**RESPONSE TO SUBMISSIONS – ASPECT INDUSTRIAL ESTATE – LOTS 54-58, DP259135 –
MAMRE ROAD – KEMPS CREEK**

Please see below responses to key items raised within TfNSW' letter dated 20 December 2022 (TfNSW reference: SYD19/01350/27).

Project	ASPECT INDUSTRIAL ESTATE MAMRE ROAD, KEMPS CREEK EXTERNAL INTERSECTION
Title	ROADWORKS AND STORMWATER DRAINAGE PLAN SHEET 1

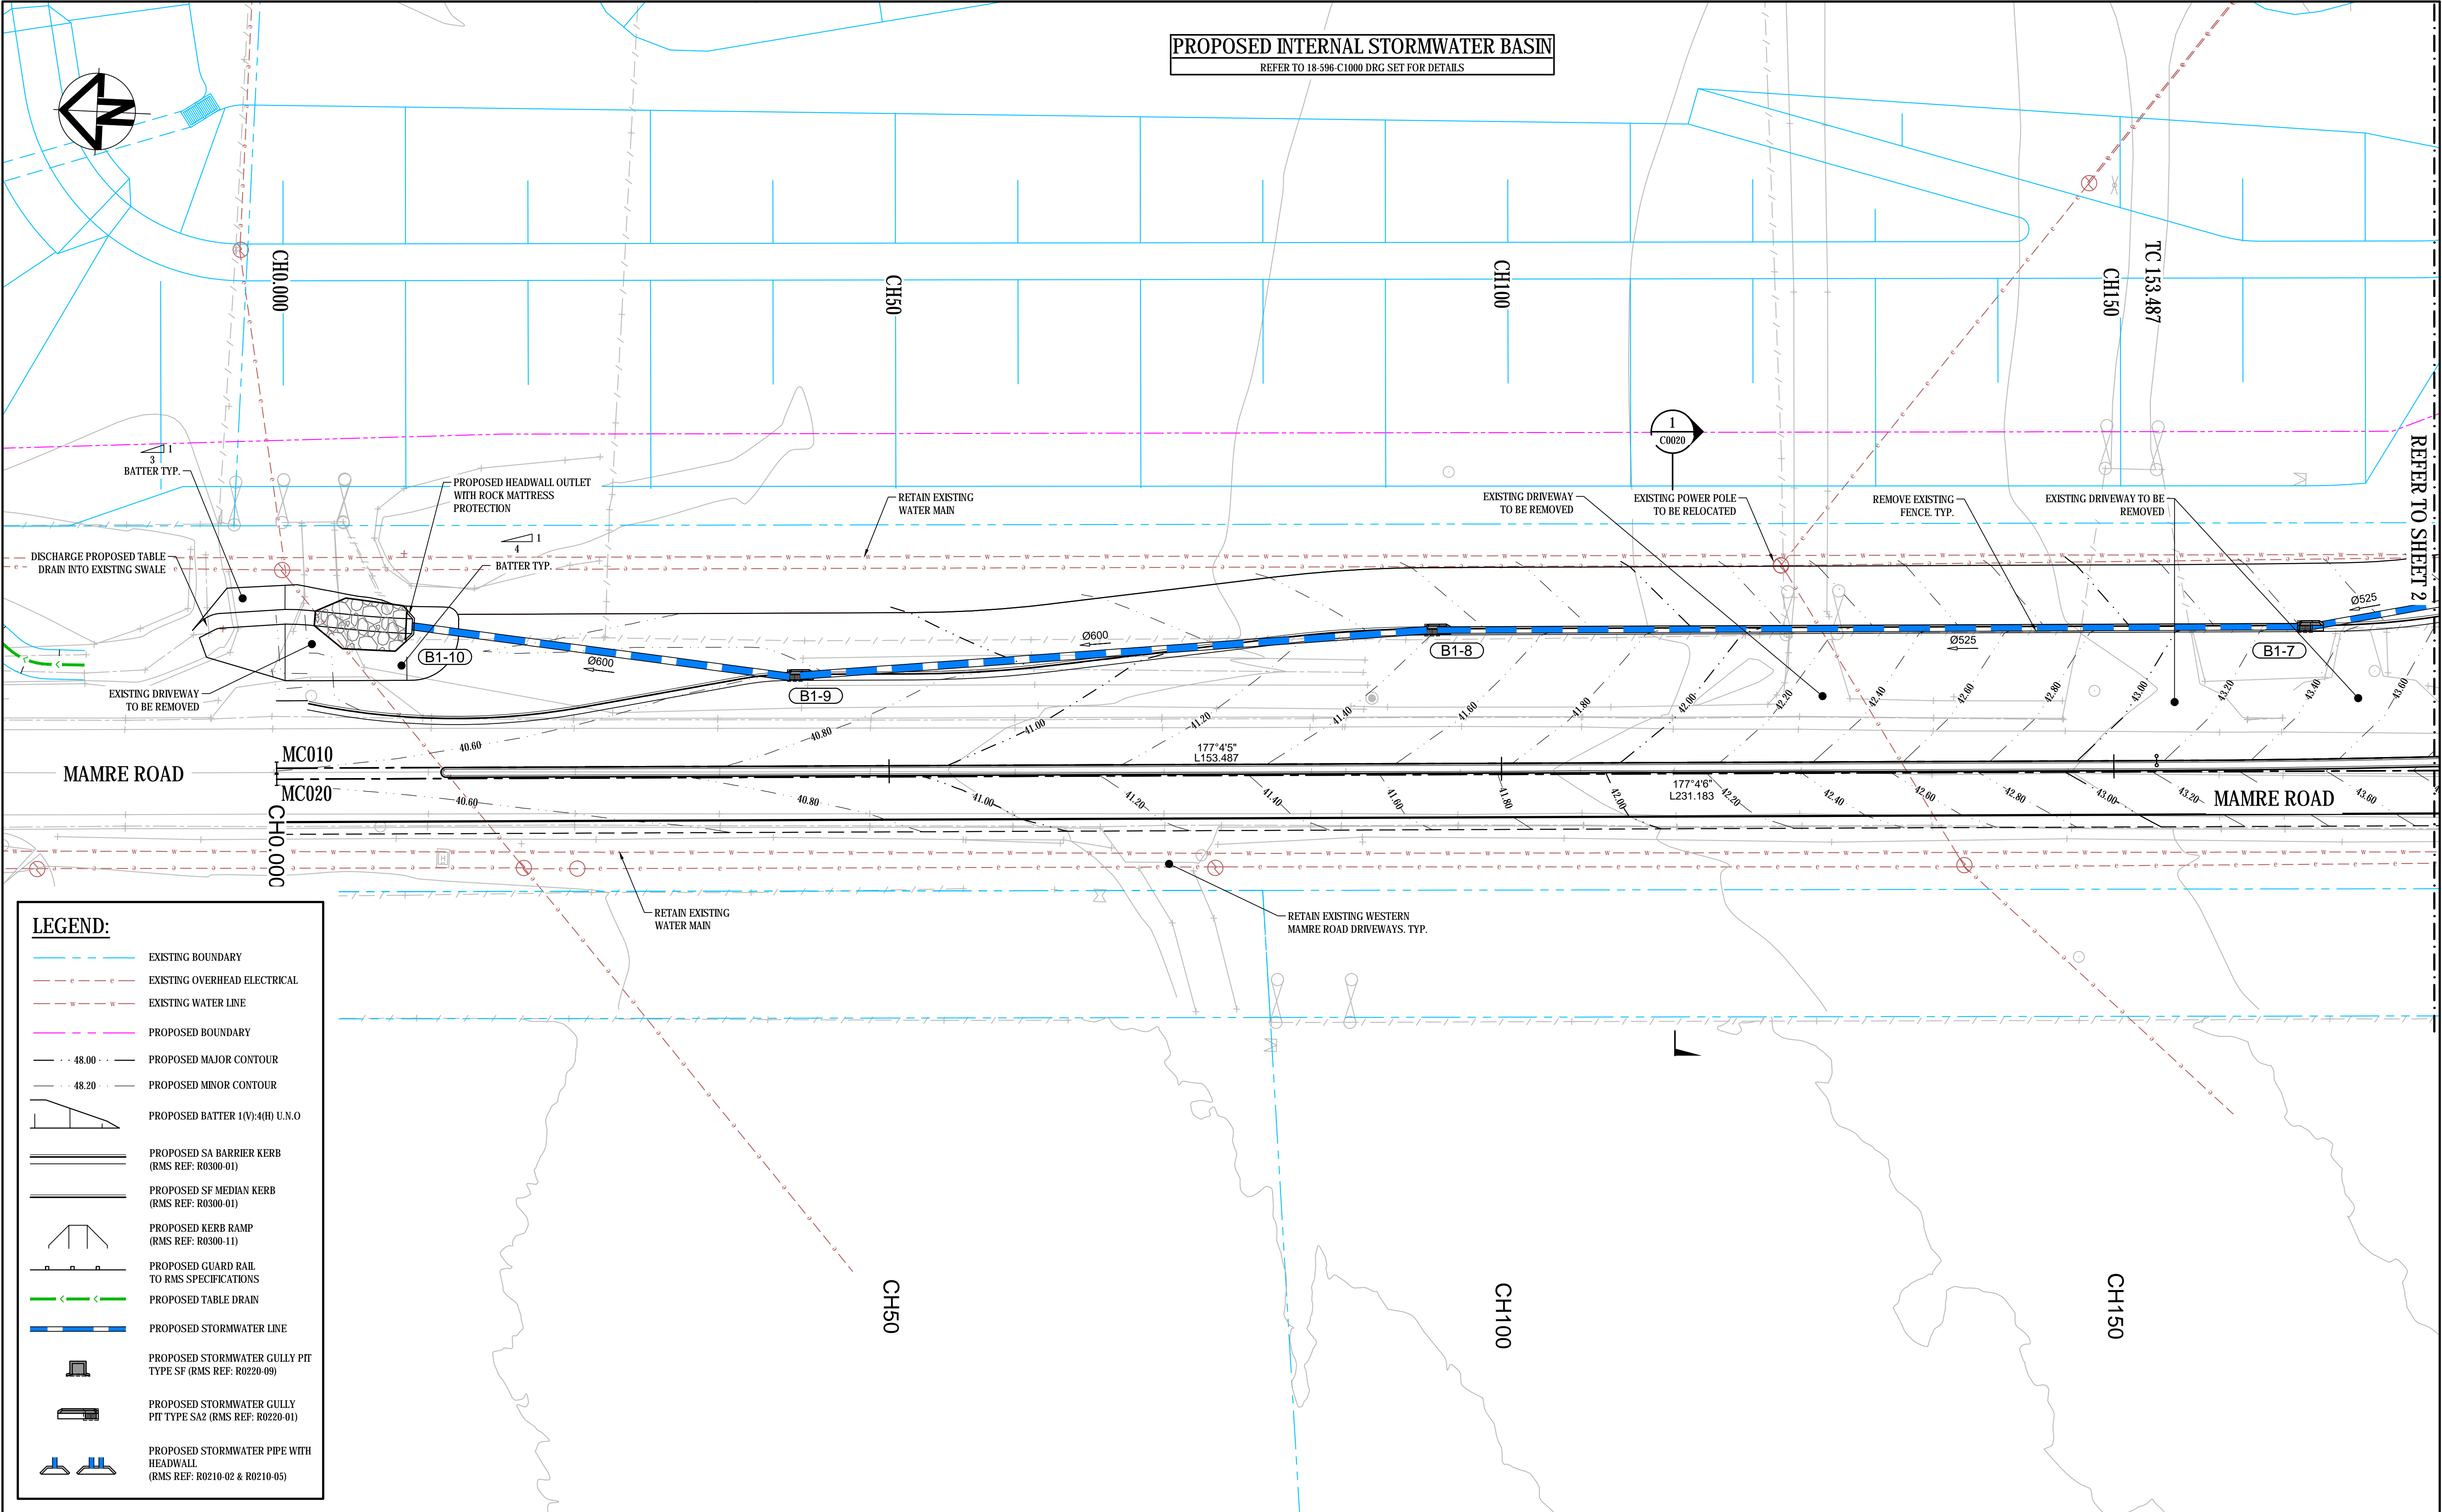
- 5) *Comment No.12 – TfNSW notes that the updated plans show access to 819-831 fall just north of the intersection and the access to 833B is located just south of the intersection. The accesses are outside of the intersection and therefore not required to be relocated.*

However there is an unofficial secondary driveway located directly in the middle of the intersection (see image 1 and 2 below). Whilst it does happen, it is undesirable to have driveway accesses within signals. Therefore as this driveway is a secondary access where alternative access to the lot is enabled to the south of the intersection, this driveway is to be removed as is not considered essential to the access to the Lot.

The secondary driveway access for number 833B Mamre Road depicted in the middle of the intersection of the draft TCS plan and other civil plans is to be removed from the signal footprint and written agreement from the landowner is to be provided prior to entering into a WAD with TfNSW.

- The Applicant must enter into a Work Authorisation Deed (WAD) with TfNSW for any works that need to be carried out on TfNSW land.
- The Applicant must remove the redundant secondary driveway within the signalised intersection on Mamre Road western verge and replace with kerb and gutter. The design and construction of the kerb and gutter on Mamre Road must be in accordance with TfNSW requirements. Detailed design plans of the proposed kerb and gutter are to be submitted to TfNSW for approval prior to the issue of a Construction Certificate and commencement of any TfNSW road works.
